REF NO: AL/23/17/DOC

LOCATION: Land at Aldingbourne Farm Shop, Nyton Road, Aldingbourne, PO20 3UL

PROPOSAL: Application for approval of matters reserved by condition imposed under AL/47/14/PL relating to condition No. 6 (Landscaping scheme), 7 (Plot boundary fences), 8 (Surface water drainage), 9 (Scheme to improve current site access) & 10 (Lighting)

Tree and Hedge Planting

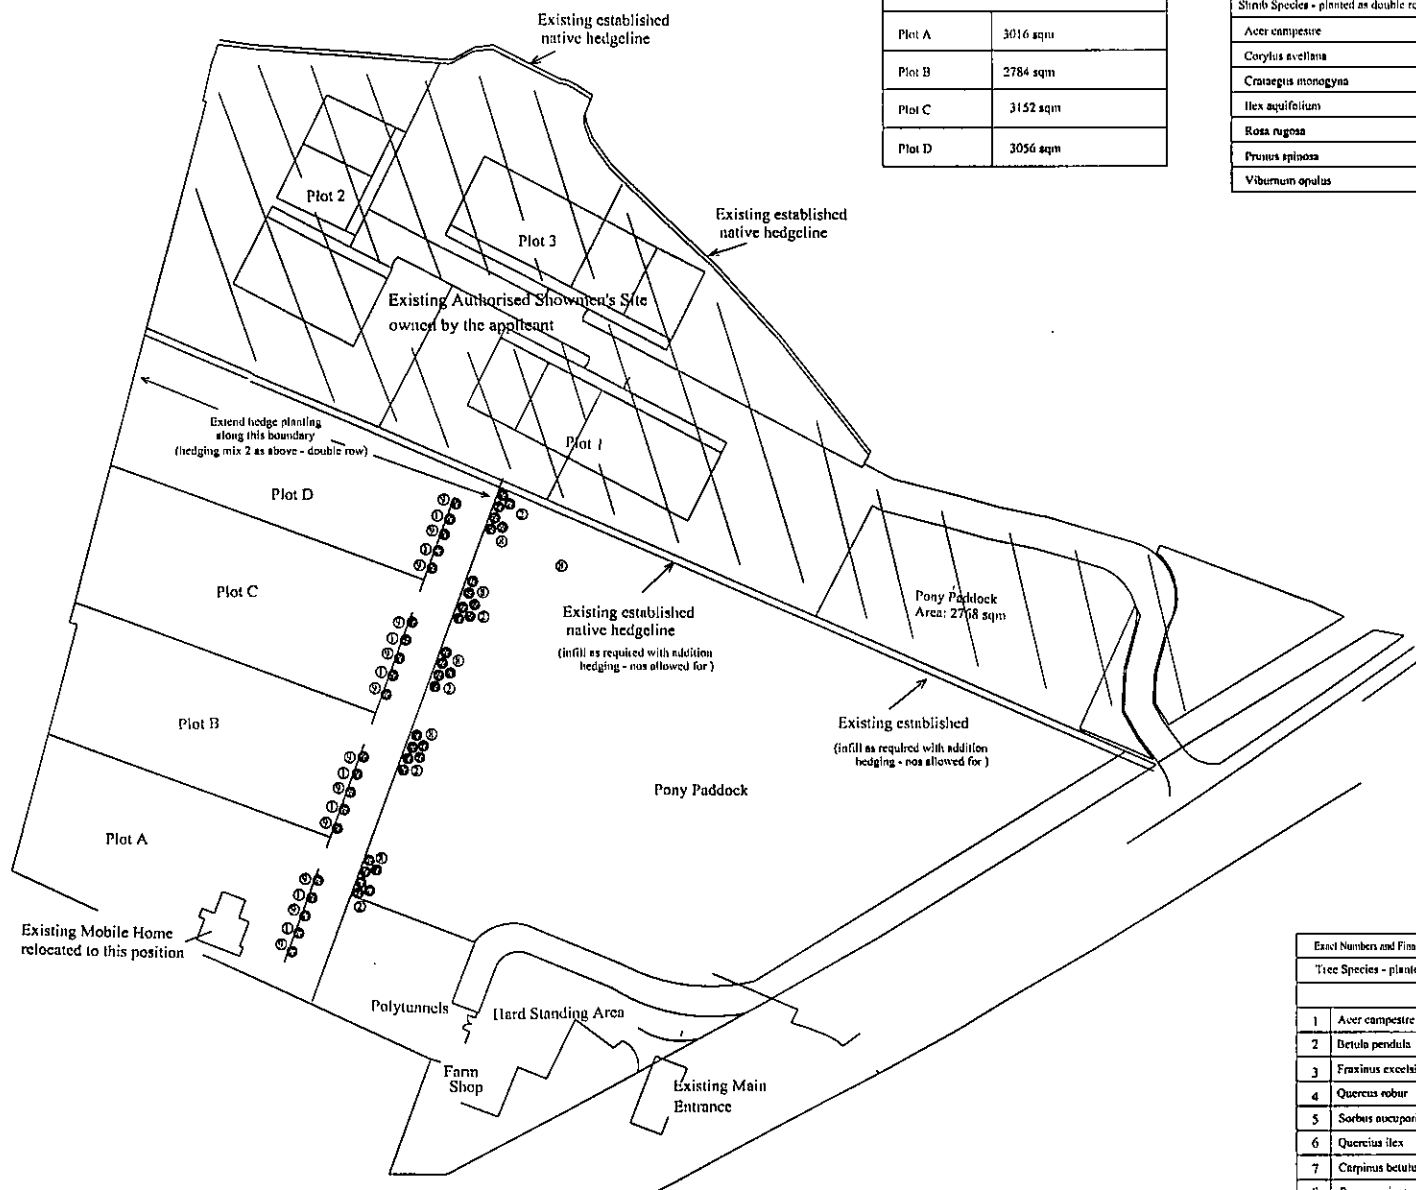
- (1) The Landscaping Plan shows very little landscaping;
- (2) The landscaping plan does not include landscaping along the western boundary to screen the site from the Marsh Lane houses;

ADC LANDSCAPE OFFICER – “I met the applicant and agent on site in November 2015 to discuss the planting requirements for this site. While the site is mostly screened from external views there are gaps which need to be filled, particularly from the adjacent footpath. The plan submitted appears to fulfil this need and gives outline details of the suggested planting, however I require a fully detailed planting plan to be able to provide

meaningful comment, particularly relating to the locations of the standard trees. I would also ask for standard trees to be incorporated along the hedge line adjacent to Plot D.”

A landscaping plan has been submitted which appears to fulfil the need to fill in gaps in the existing screening but does not specify the location of individual trees. Furthermore, although the plan suggests enhancements to the hedgerow between this site and the site to the northwest, it does not detail where the enhancements are to be made. This therefore gives the impression of there being less landscaping than what may actually be proposed. The Landscape Officer also requests that standard trees be incorporated along the hedge line adjacent to Plot D.

This condition cannot be discharged without the submission of a more detailed plan and given that the applicant has had ample time to submit such a plan, the application must be refused.

Advice received from the Councils Landscape Officer on 24/04/17 is that the submission does not provide a sufficiently detailed plan showing the location of trees and the location of infill enhancements to the existing hedging. Without this level of detail, it is not possible to agree the planting scheme. It is also requested that standard trees be incorporated along the hedge line adjacent to Plot D. The requirements of the condition are therefore not satisfied and the condition is not discharged.
